ADDENDUM 1

Re: Addendum No. 1 to the Bidding Documents for:
Gould Restaurant
Portland, Maine
Project No. 12752

This Addendum forms a part of the Contract Documents and modifies the original Bidding documents dated 9/23/2013, Re-Issued for Construction.

B1 ROOM A201 WEST ELEVATION
SCALE: 1/4" = 1'-0"

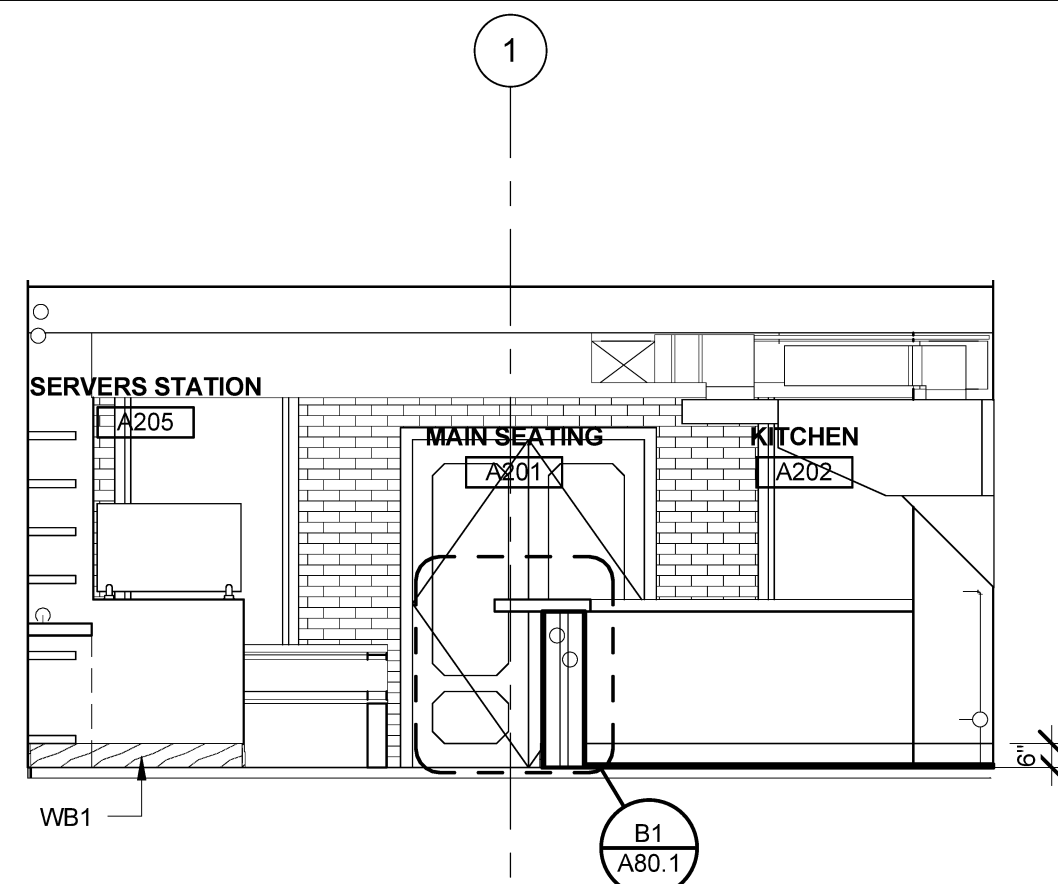
- a. Per SKA01, Revise Drawing B1, Room A201 West Elevation as shown
